LITTLEHAMPTON CIVIC SOCIETY

Comments on LU/287/17/PL

12th October 2017

Appendix 1, Plan 19 – Proposed Side / West Elevation

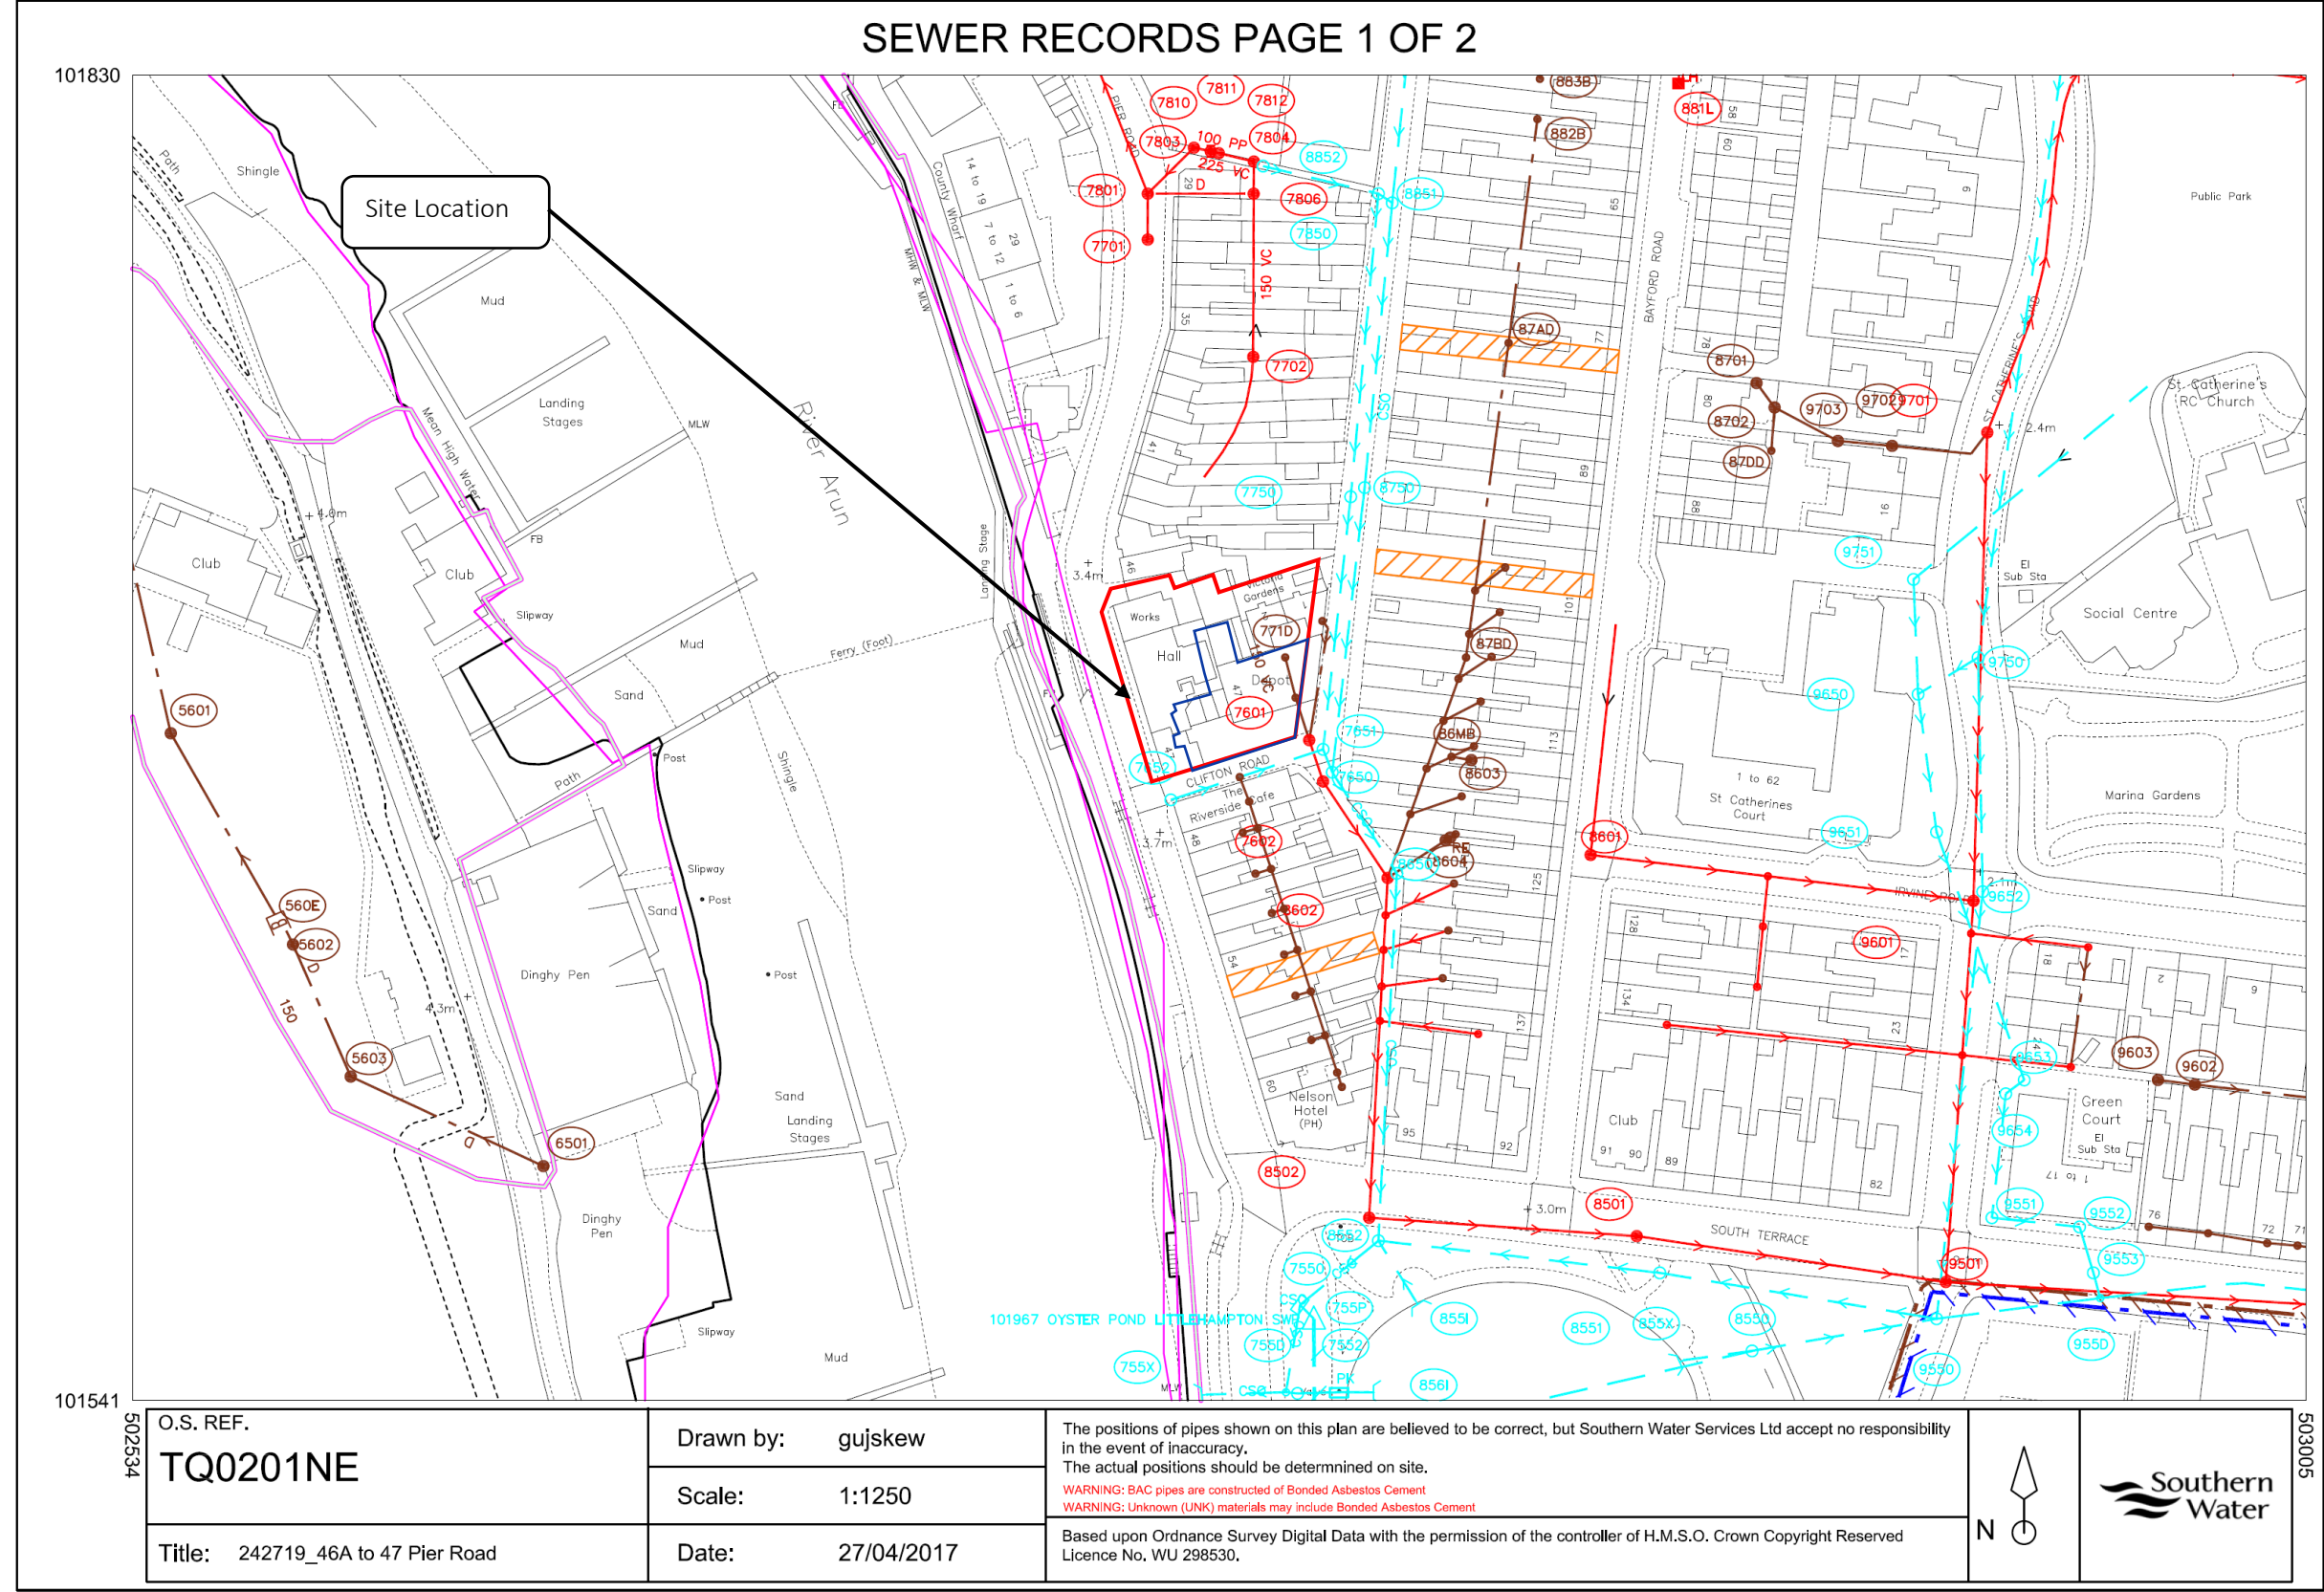
The application itself is for a bland, slab-sided three-storey block (although the application appears to state it is two storeys), the like of which are perhaps too many in Littlehampton. The eight flats on top of an office space contribute to area housing allocation targets but, beyond that, contribute little to heritage, tourism and the future economic growth and vitality of Pier Road and its maritime and riverfront culture.

The building has a flat roof, quite out of keeping with neighbouring properties, all of which have pitched roofs. If this proposal were to have a pitched roof, it would be much higher than its neighbours and compromise the street scene.
